From: Martyn White
Sent: 15 October 2018 12:21
To: Planning.Responses
Cc: Zac Denton
Subject: AB/77/18/PL & AB/78/18/L

AB/77/18/PL & AB/78/18/L

PROPOSED Casement Window Details (Guest Bedroom 3 window replacement)

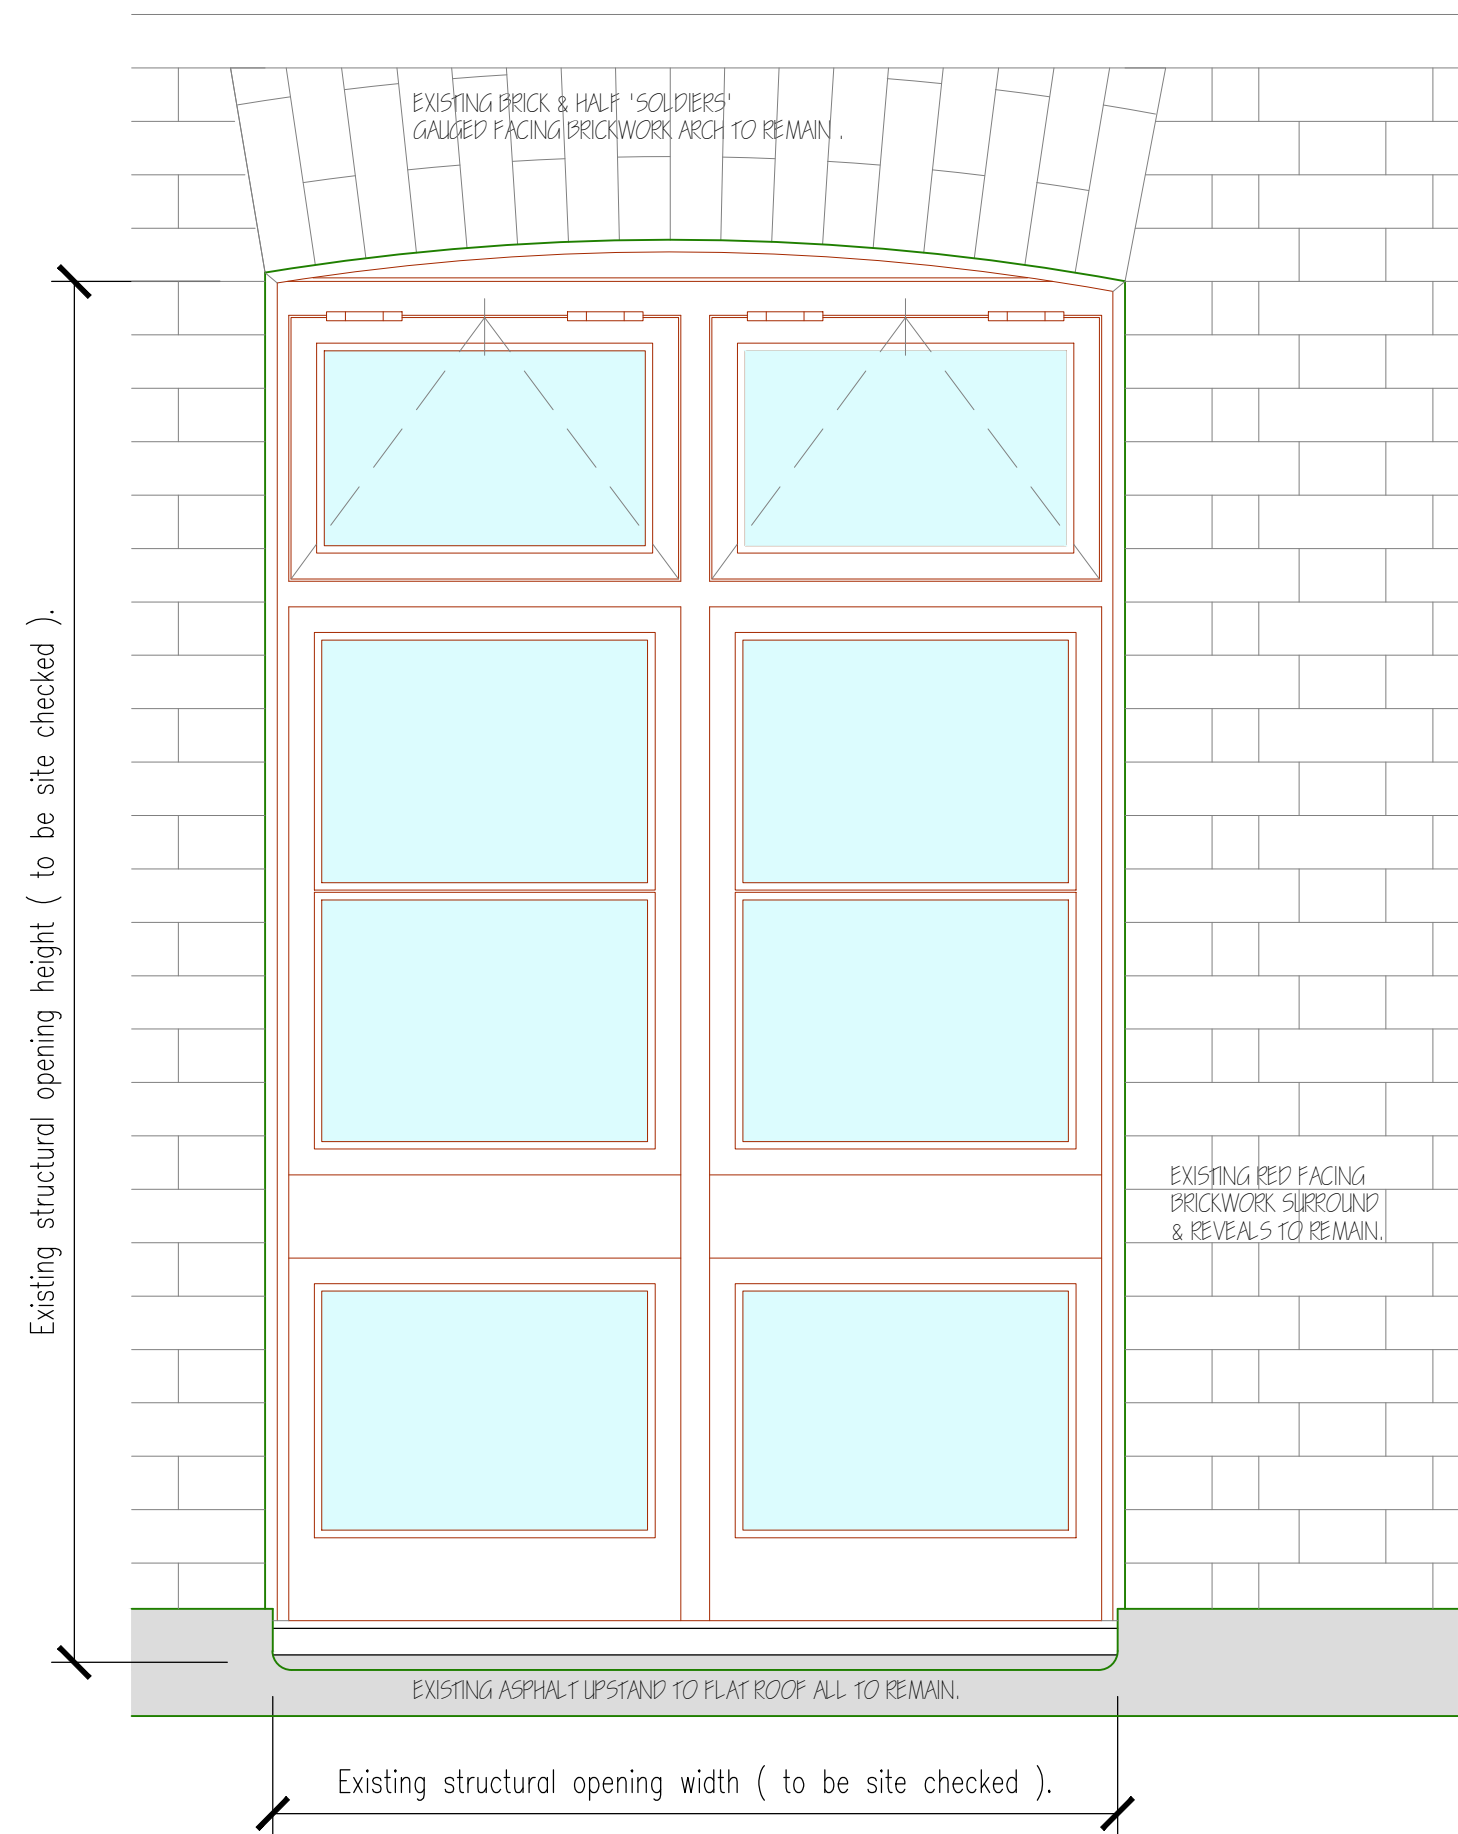
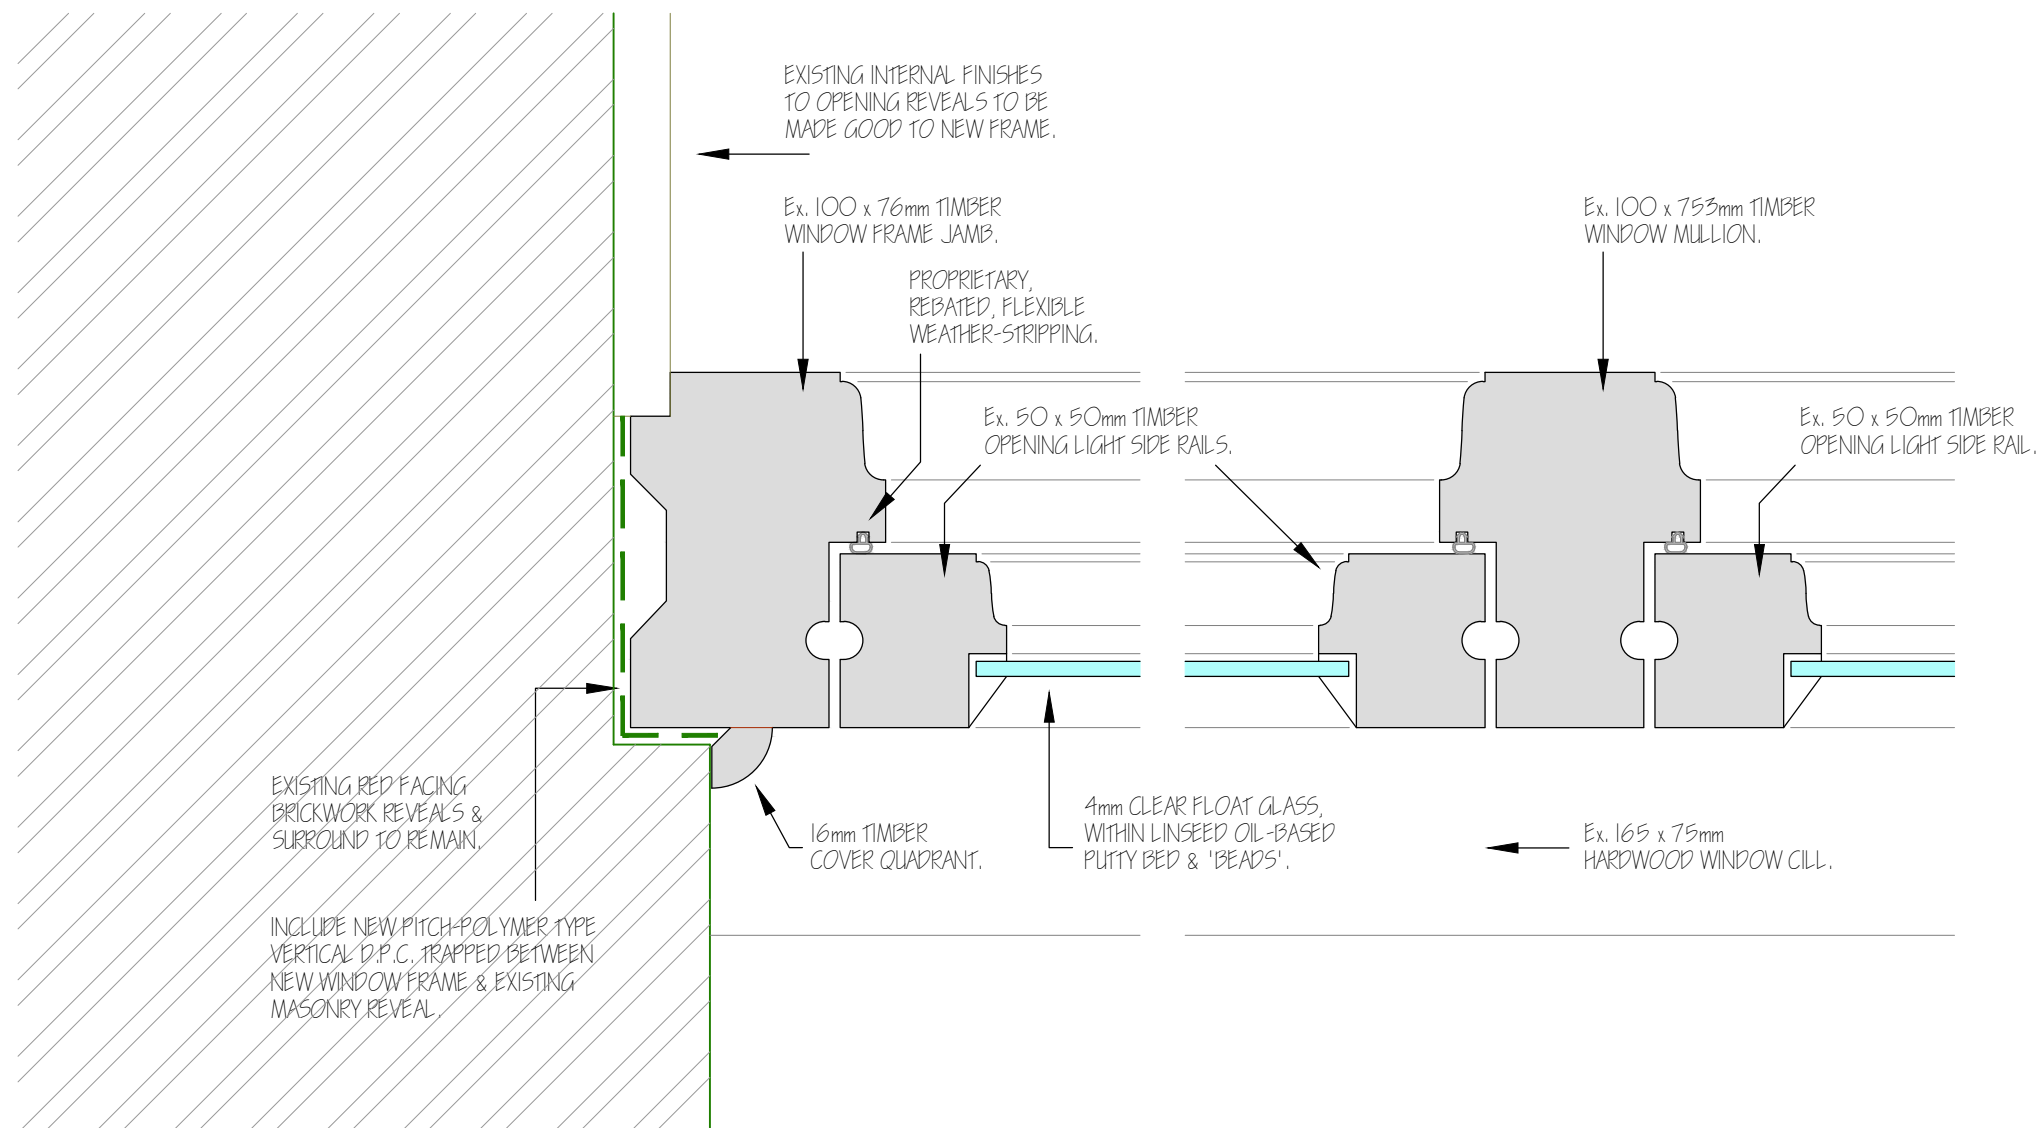
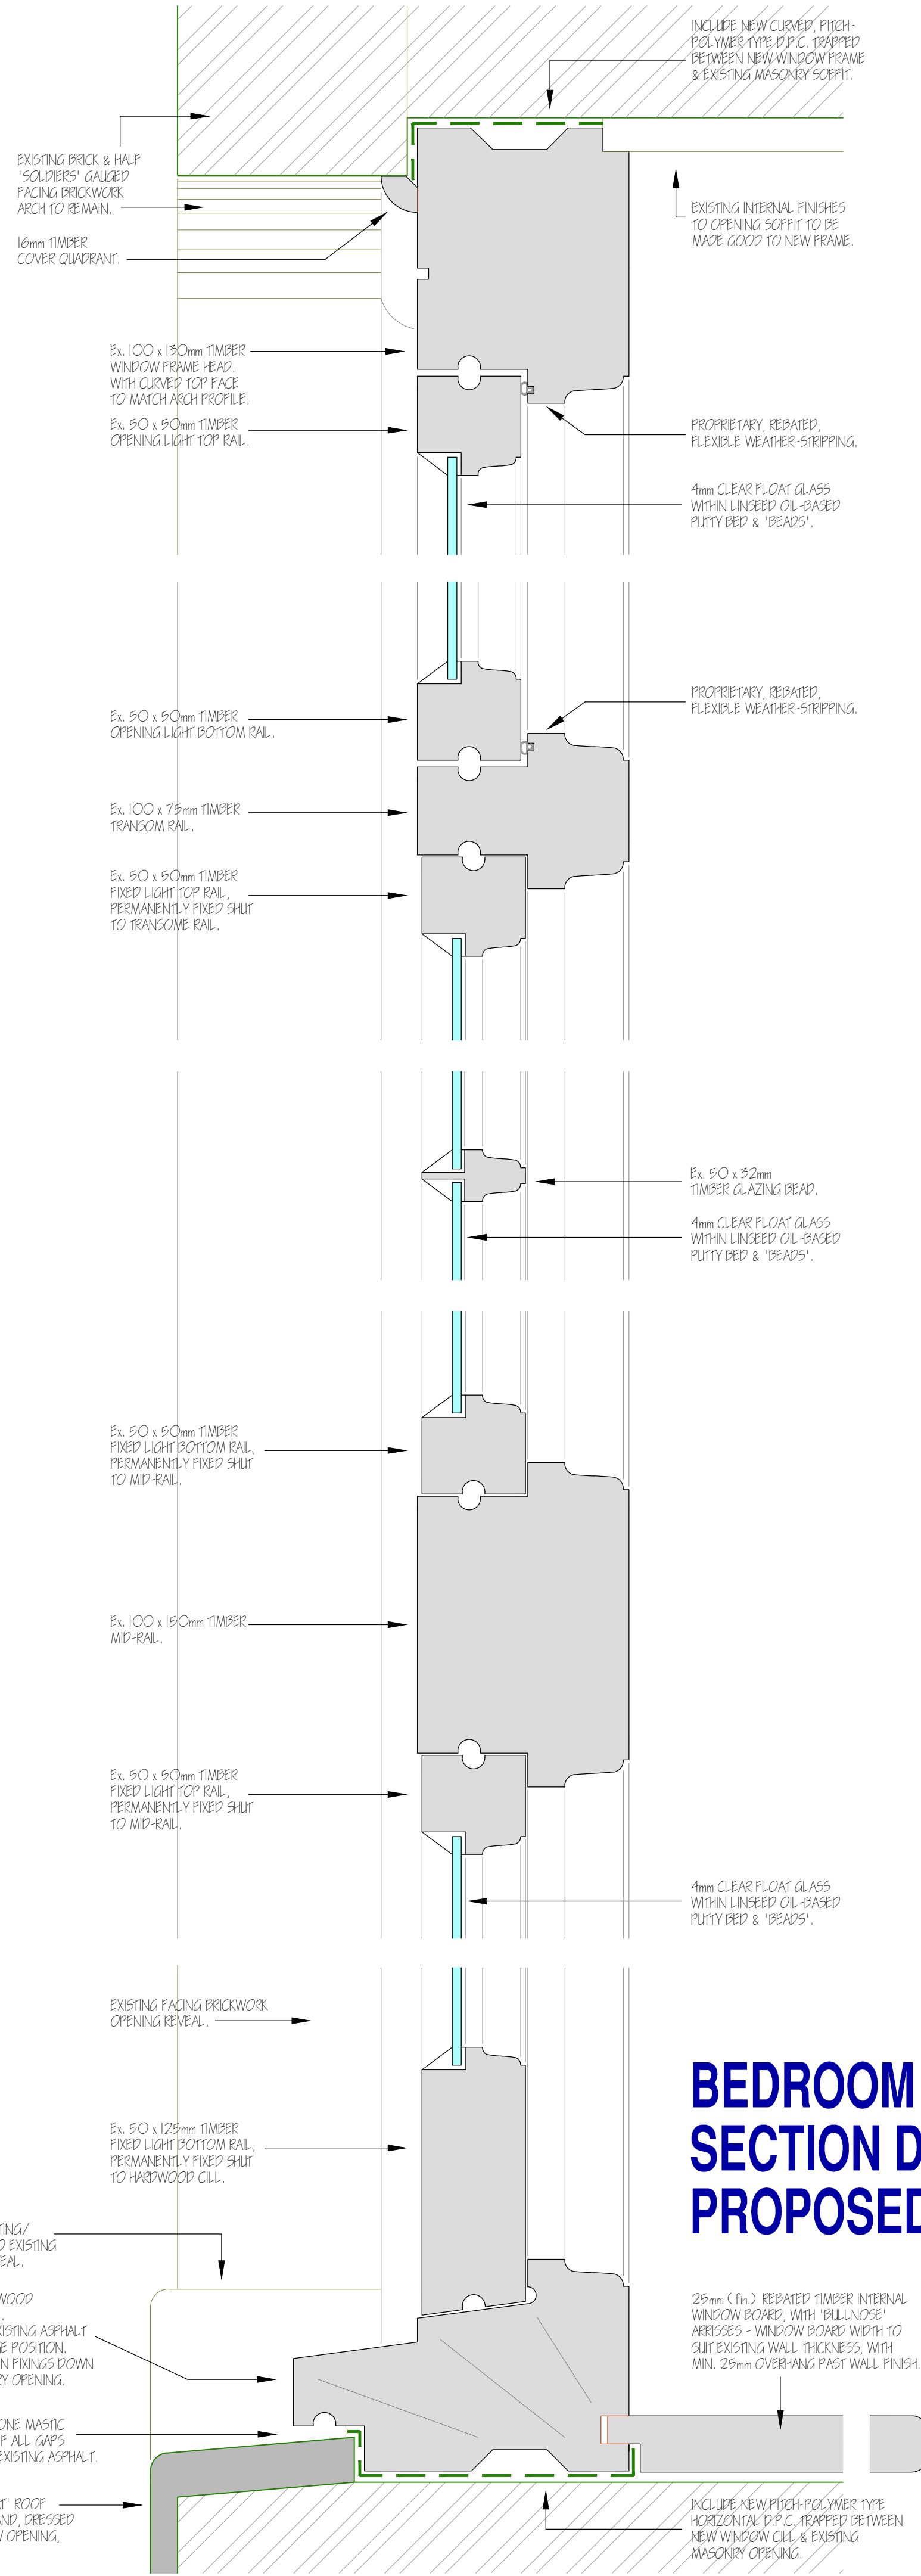
I note that the proposal is to refurbish existing windows, rather than replace them. However, if it is noted that windows are beyond repair, the department should be contacted so that an approach can be agreed prior to works commencing.

PROPOSED
G.A. Part Ground Floor Plan.

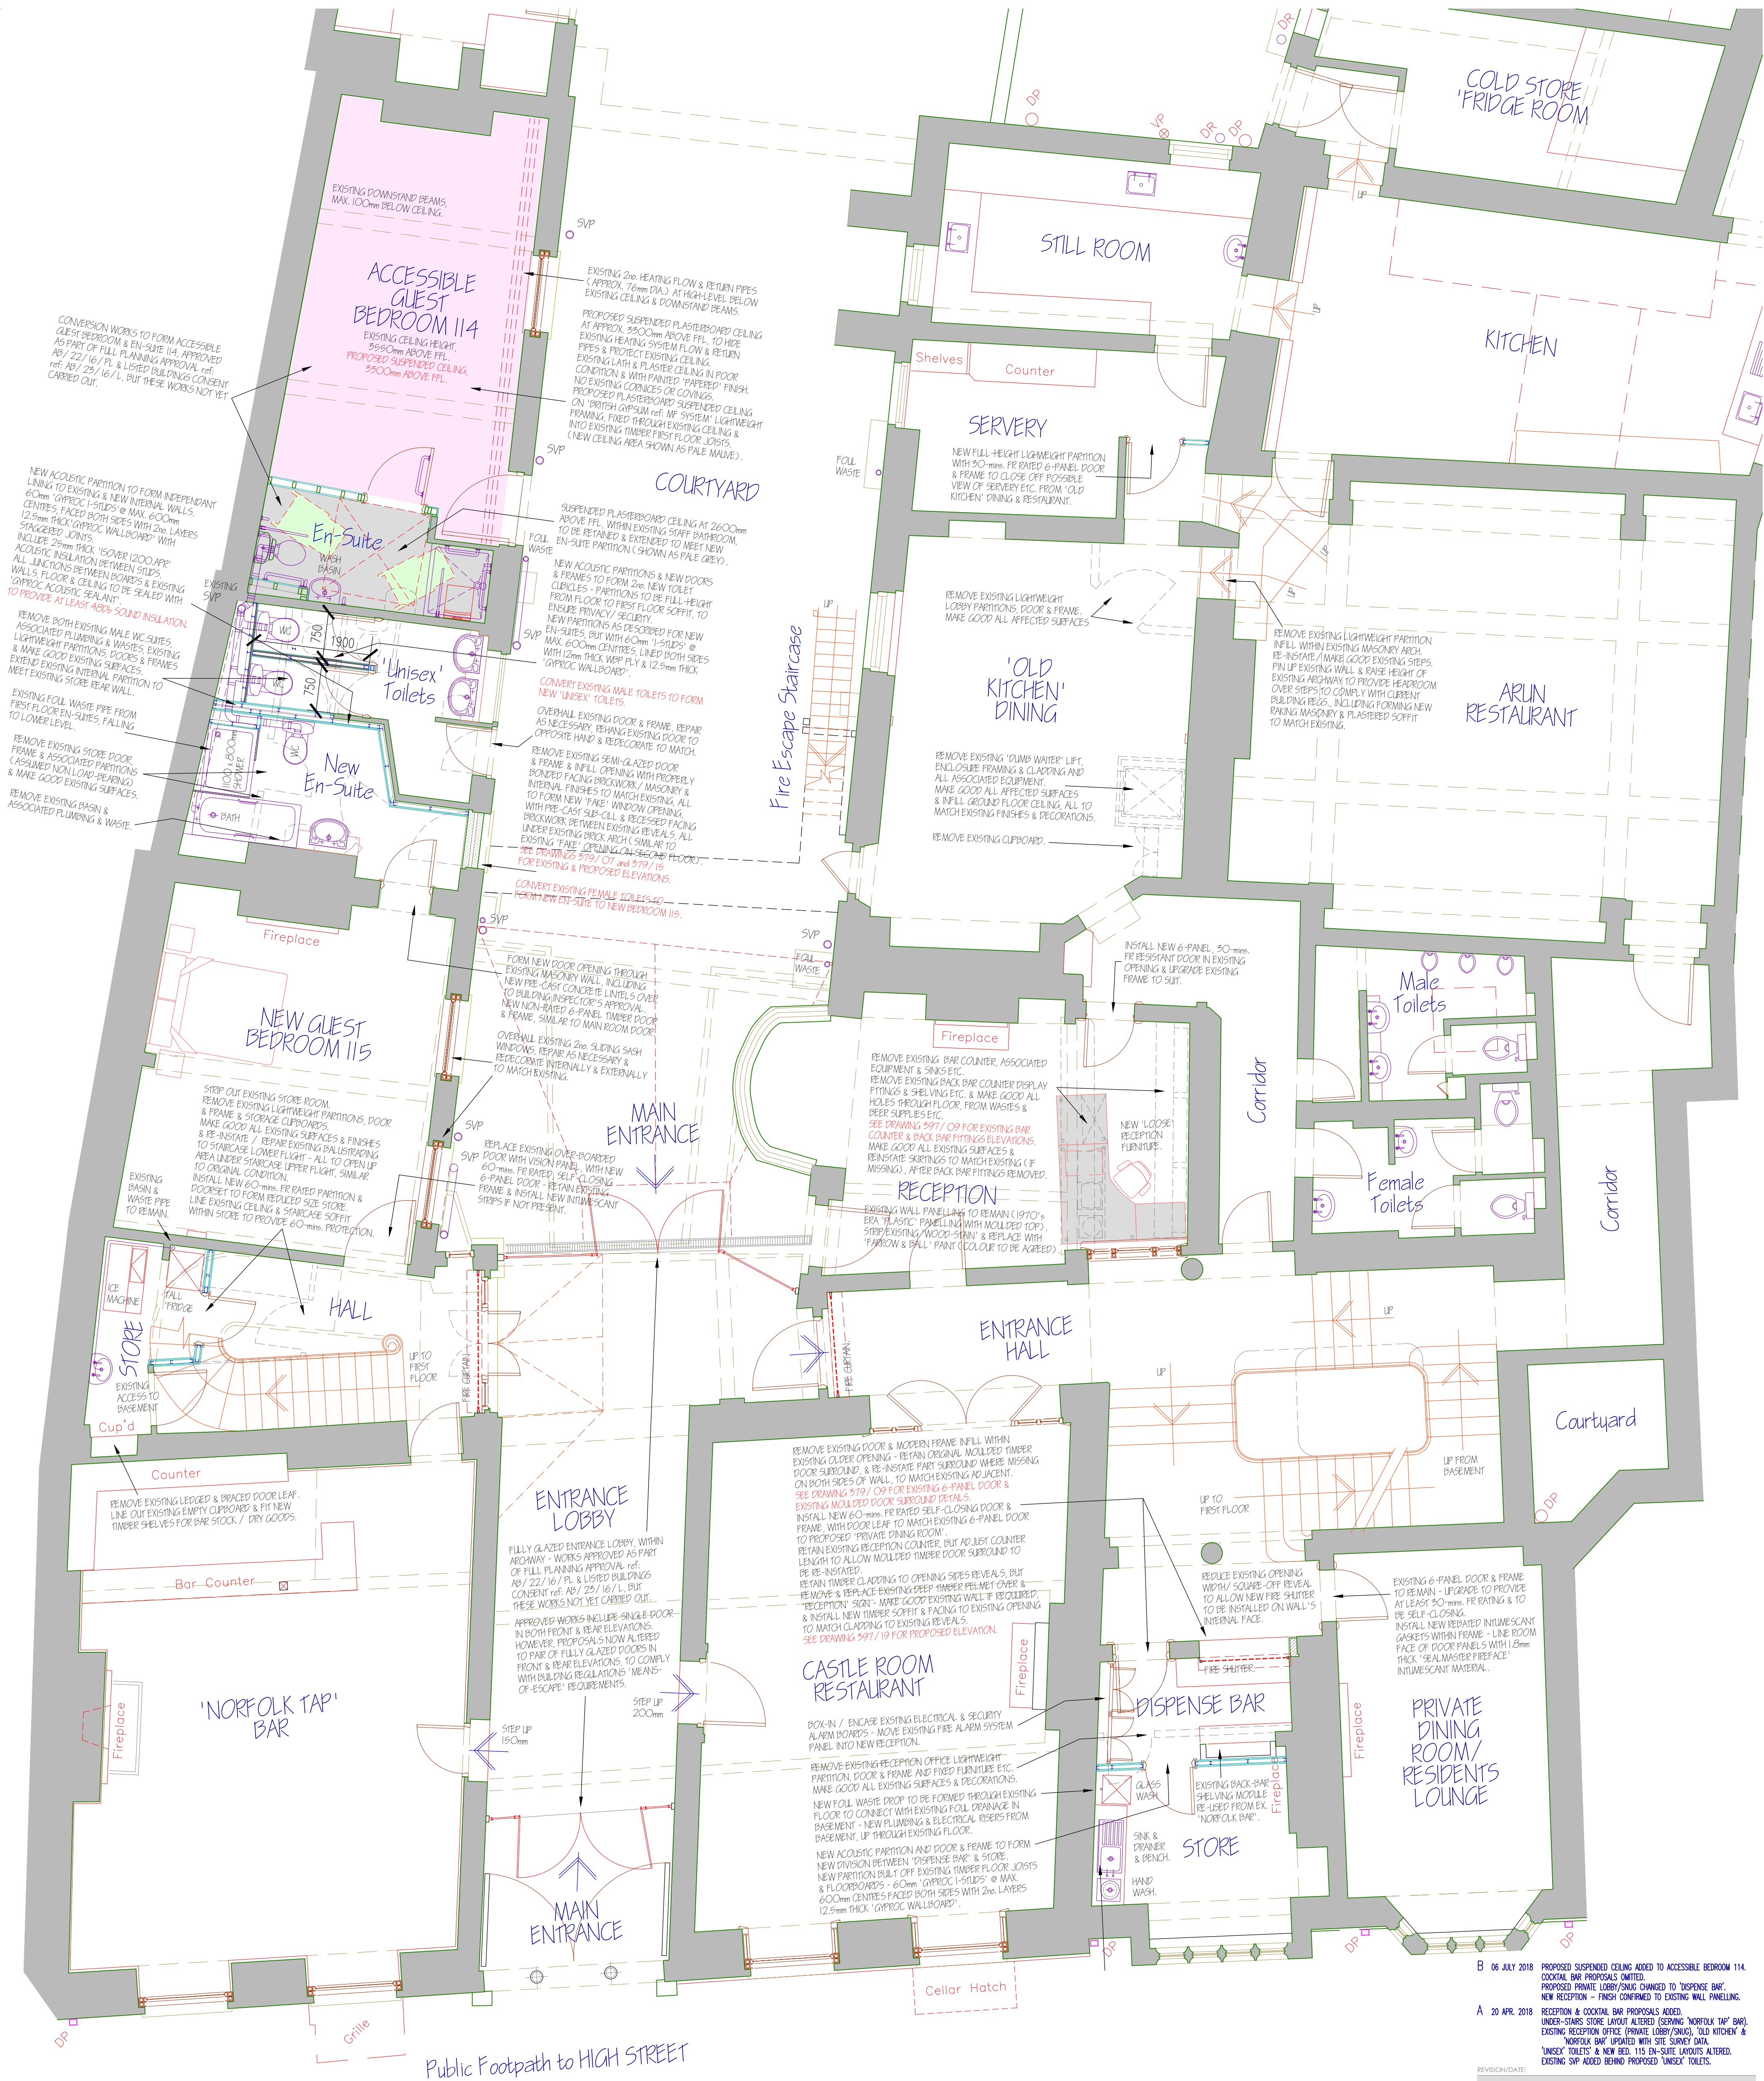
Works to the ceiling on the ground floor bedroom are acceptable, and the works are considered to be reversible. As a result, they will not harm the character of the space concerned.

The provision of an additional en-suite to bedroom 17 is acceptable subject to confirmation that drainage can easily be accommodated. In addition,
